Our Ref: R/153/19/HH
Your Ref:

Town & Country Planning Act 1990 (as amended)
Town & Country Planning (Development Management Procedure) (England) Order 2015
Application for Planning Permission for Works or Extension to a Dwelling

Development Retention of fence on north & north east
Location 32 Broadmark Lane Rustington

New Proposed Fencing

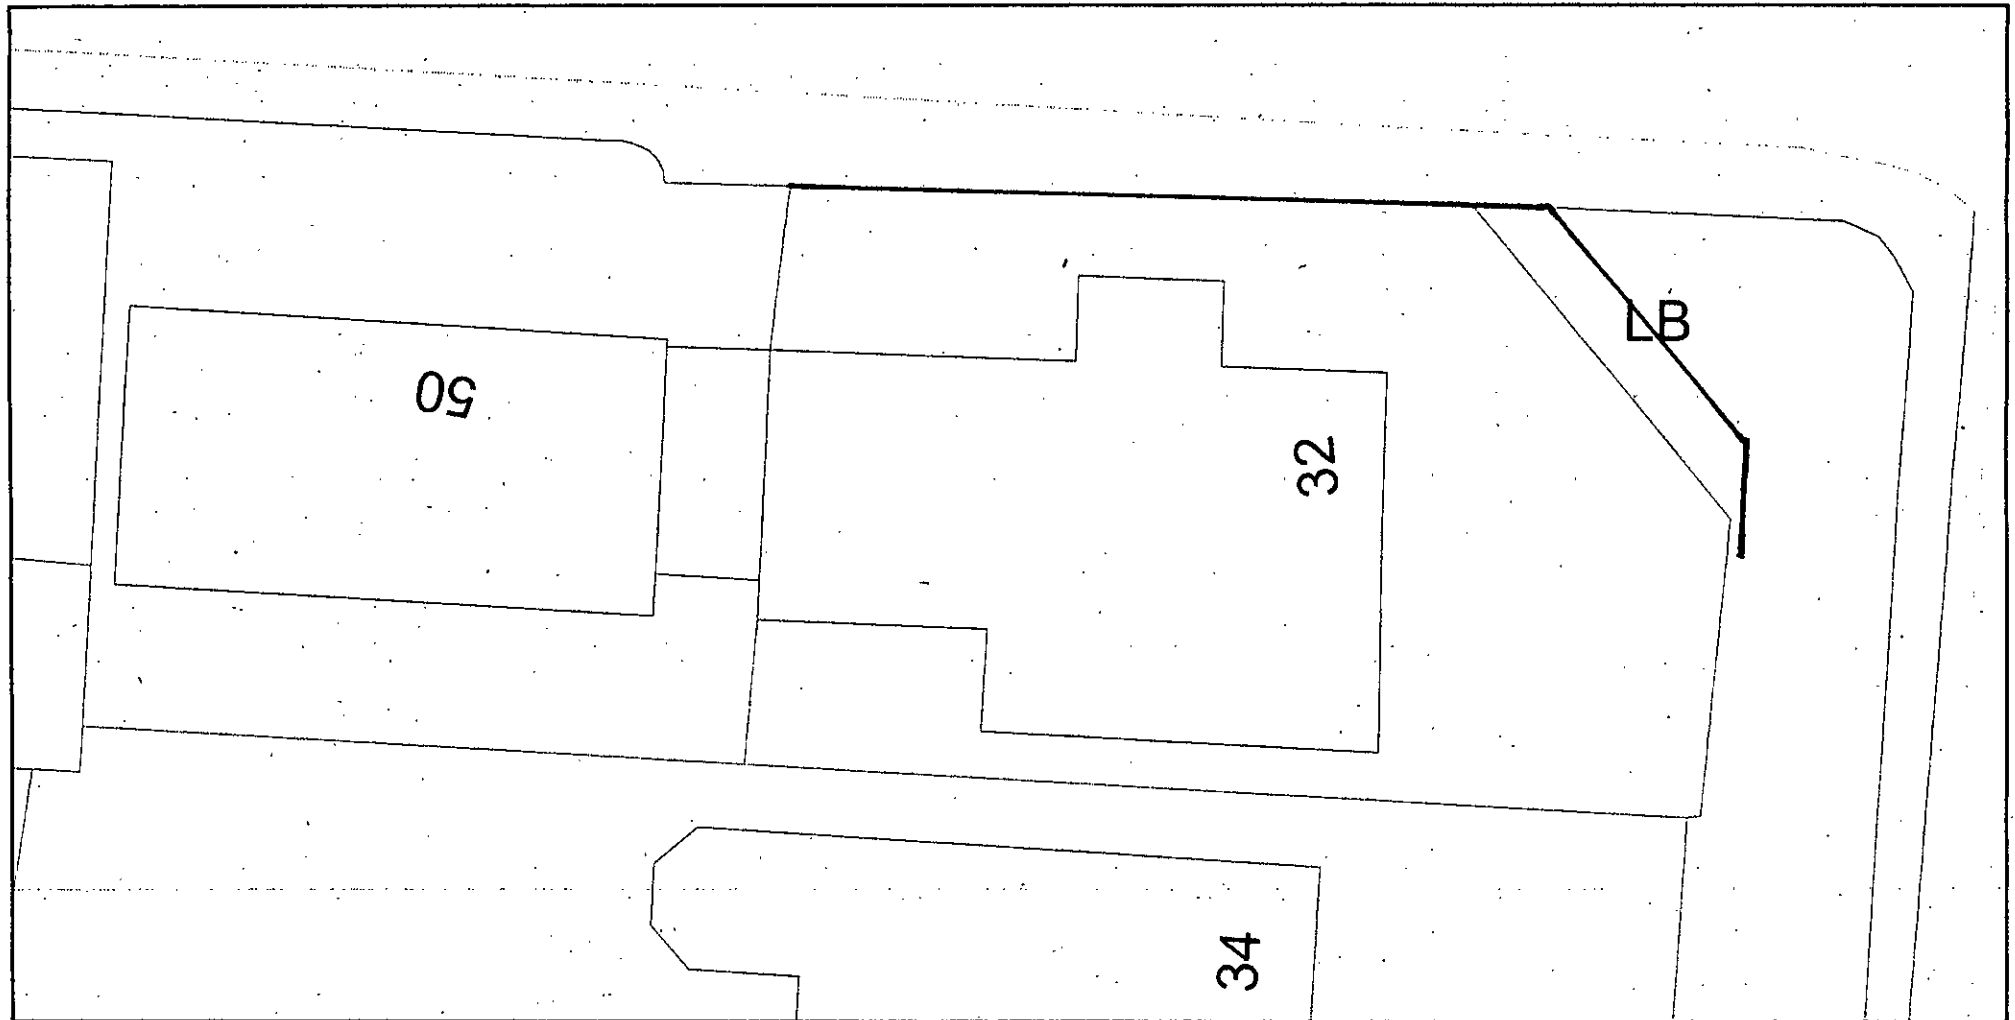
Location Plan Amend

Please only red edge the property site.
